Office of
Environment
& Heritage

DOC16/135117
15/10746

Draft Mamre West Rezoning Proposal

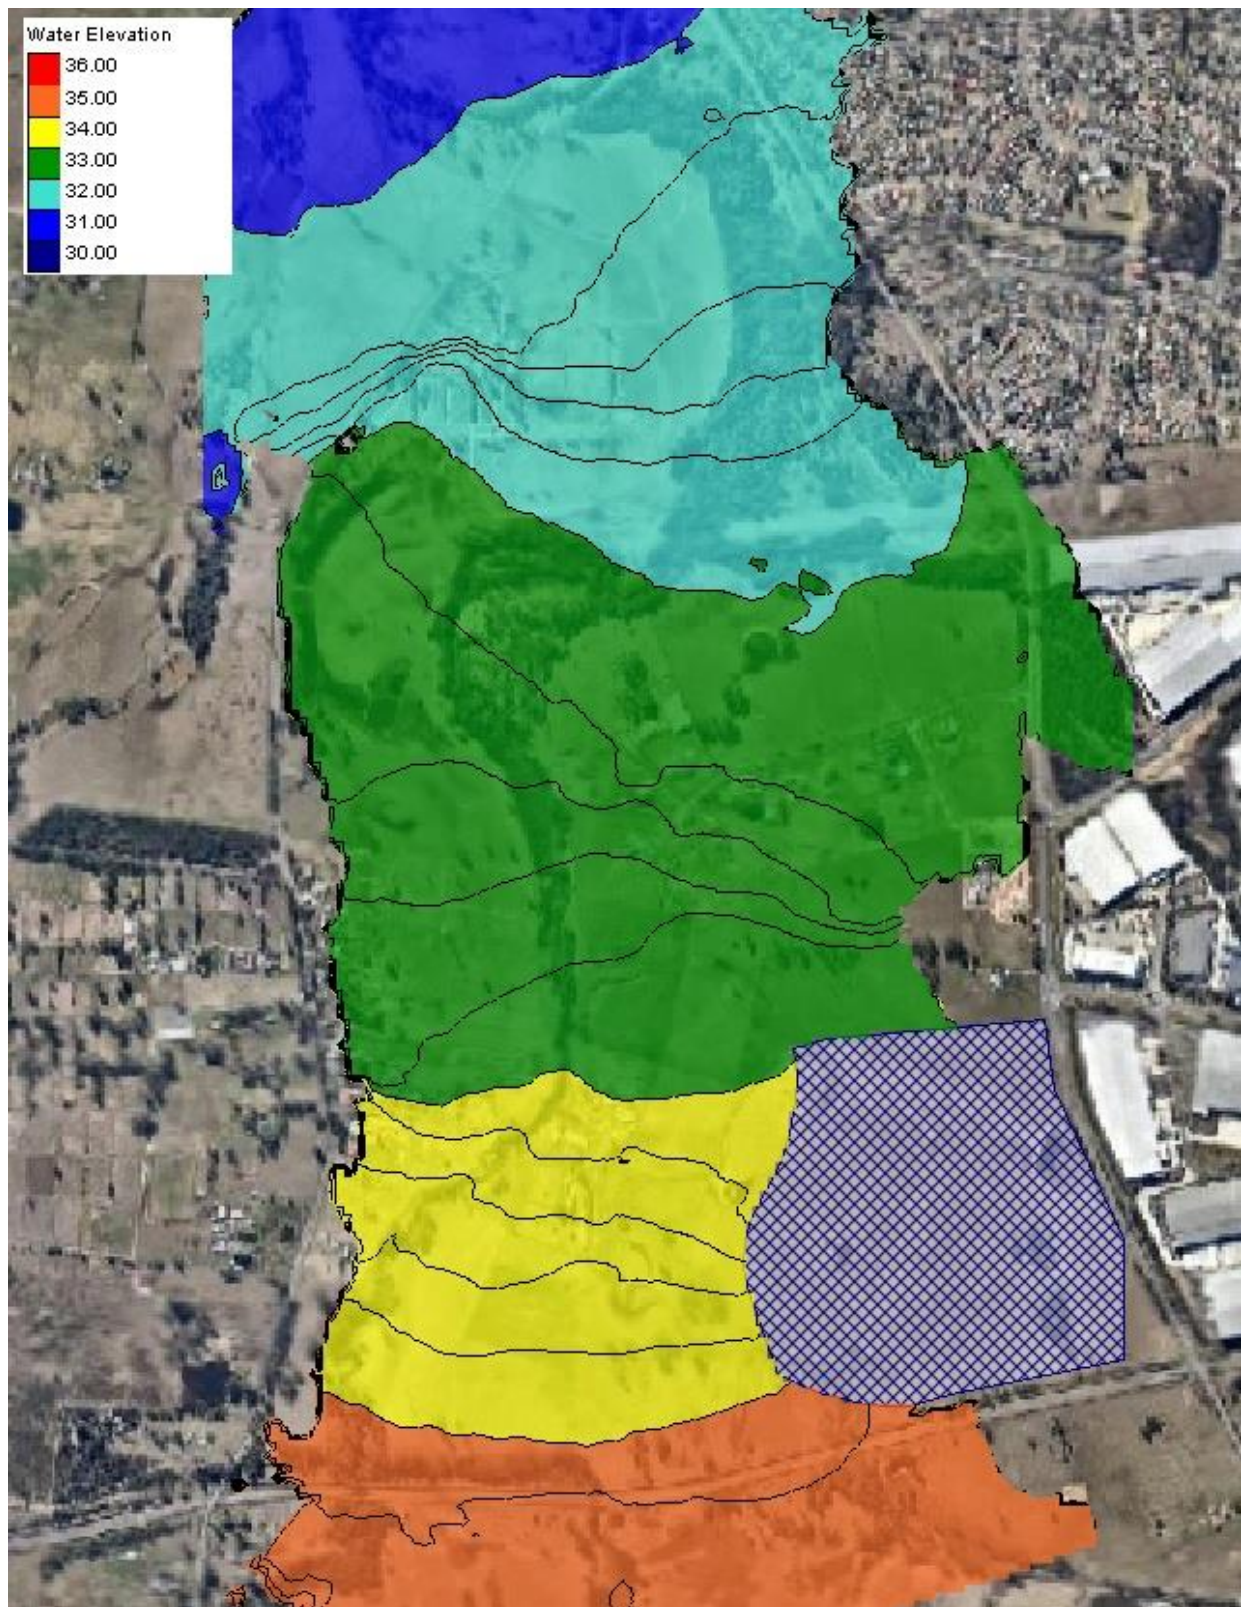
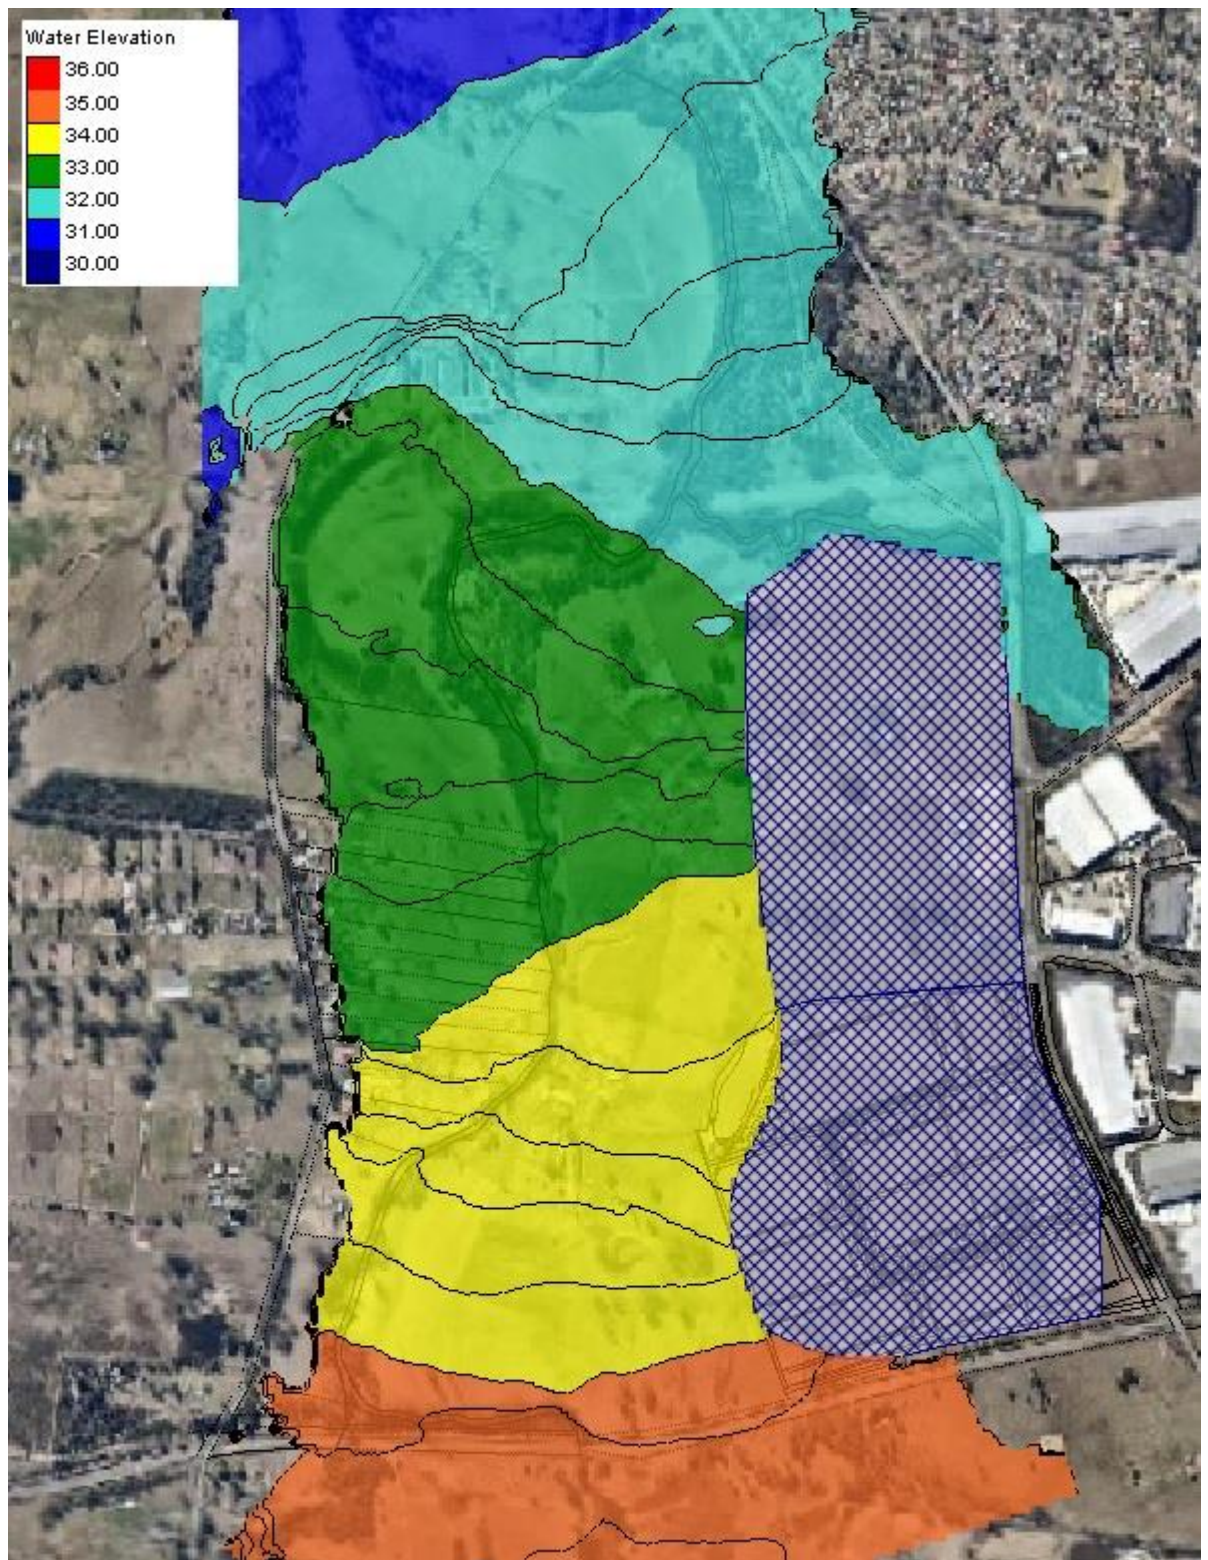
OEH is unable to assess the flood modelling outputs of the impacts of the proposed development on adjacent properties that support the staged Scenarios C and D. With regard to the area to be excavated, OEH recommends it be graded to freely drain to South Creek, be stabilised by at least grass cover and prohibited from any future filling.
